WEST WALLSEND CONTINUED OPERATIONS PROJECT EXTENSION (MP 09_0203 Mod 1)

The Hunter Branch of the National Parks Association of NSW (NPA) wishes to comment on the modification request for extension of the West Wallsend Continued Operations Project (application no. MP 09_0203 Mod 1 – ‘the project’).

FIGURE 6.4

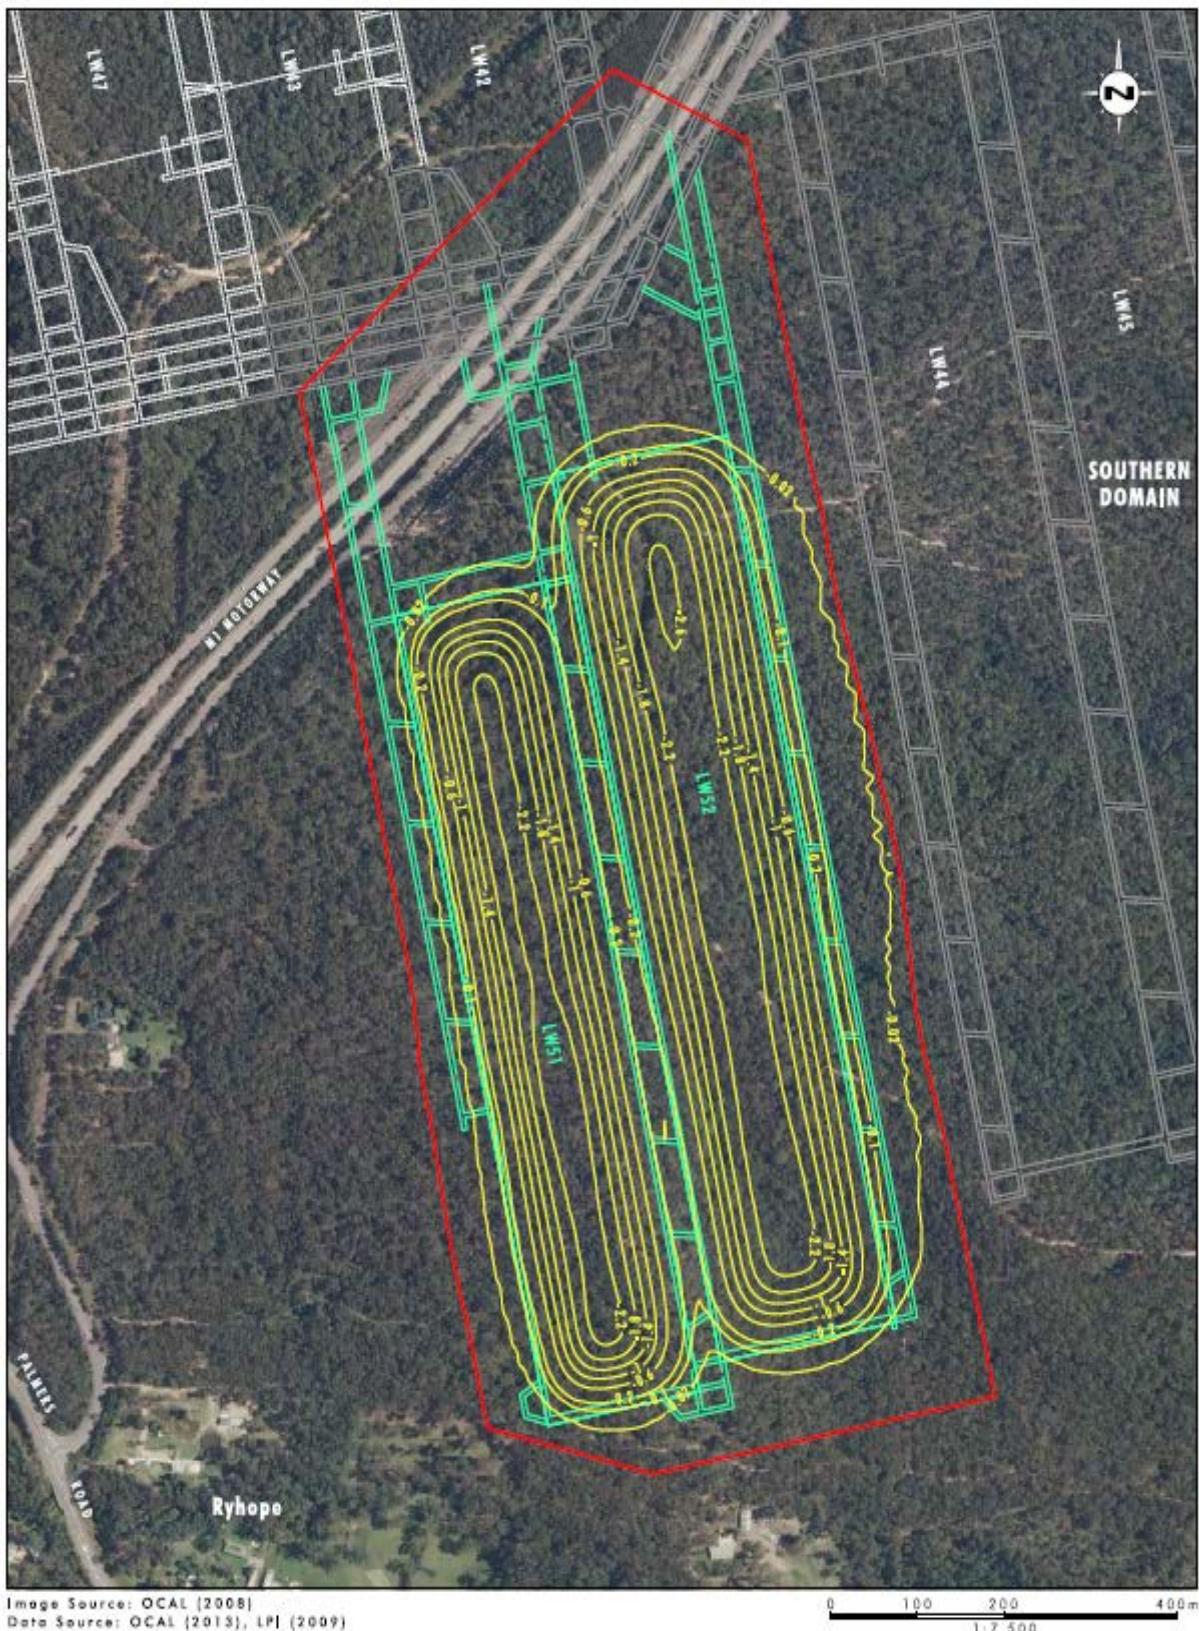
Following reports on the inaccuracies of subsidence predictions for Longwall 41 it is difficult to understand how subsidence of an undulating landscape, such as exists in the Longwall 51 & 52 project area, could possibly occur as uniformly as is shown in Figure 6.4 *Predicted Subsidence* of the Environmental Assessment.
